Application number: 2026/91651	
What is the application for?:	Erection of first floor rear extension
Address of the site or building:	367, Bradford Road, Fartown, Huddersfield, HD2 2QN
Postcode:	HD2 2QN

Type of comment: An objection	
Do you wish your comments to be published on the website anonymously?	Yes
<p>I am writing to formally object to the above planning application for a first storey rear extension, which will have a significant and harmful impact on my home.</p> <p>1. Loss of Sunlight and Daylight The proposed extension will substantially reduce the natural light entering the rear rooms of my property. Due to its height, depth, and proximity to the boundary, the structure will:</p> <p>Cast shadows over my windows for much of the day</p> <p>Reduce direct sunlight into my living spaces</p> <p>Create a sense of enclosure and overshadowing</p> <p>This is contrary to the principles outlined in the BRE "Site Layout Planning for Daylight and Sunlight" guidelines, which local authorities commonly use to assess the impact of extensions on neighbouring properties.</p> <p>2. Overbearing Impact and Loss of Residential Amenity The scale and massing of the proposed first storey extens

First Floor Layout 1.100

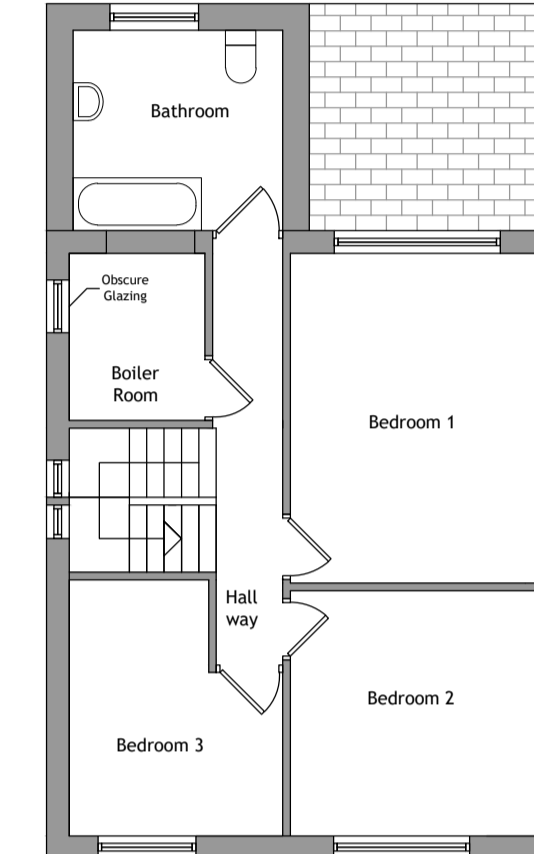
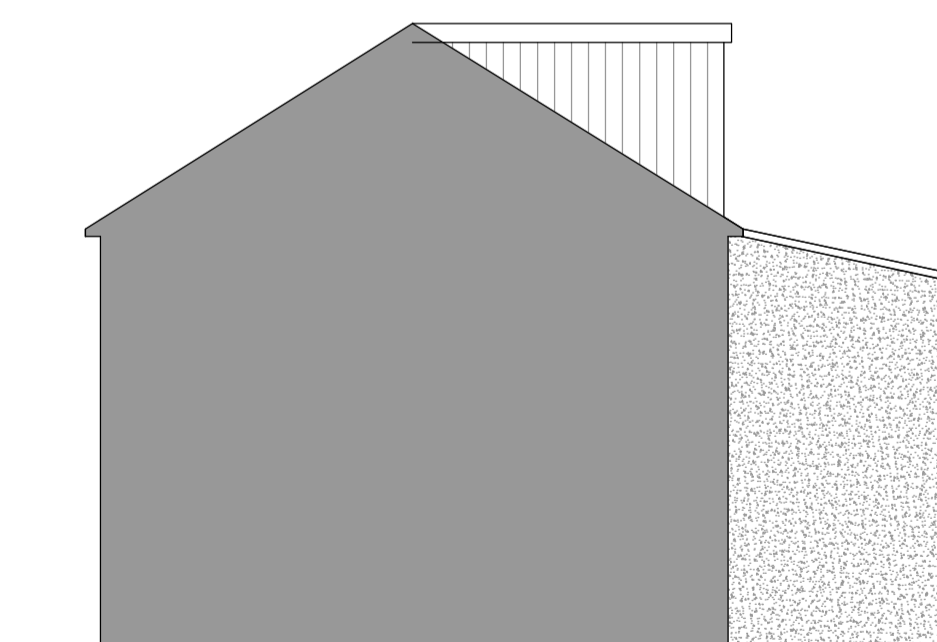
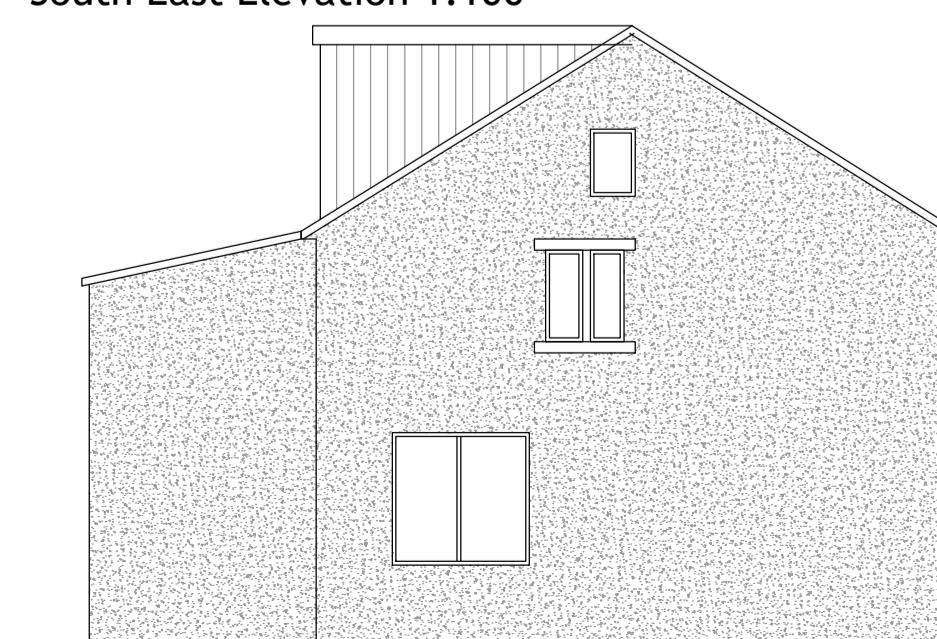
This raises concerns under local environmental health standards and Policy relating to residential amenity, which requires developments not to cause unacceptable harm to neighbouring residents.

4. Non Compliance with Local Planning Policies

The proposal appears inconsistent with local planning policies relating to:

Protection of neighbouring amenity

Avoidance of overshadowing

Maintaining adequate daylight

Preventing overbearing development
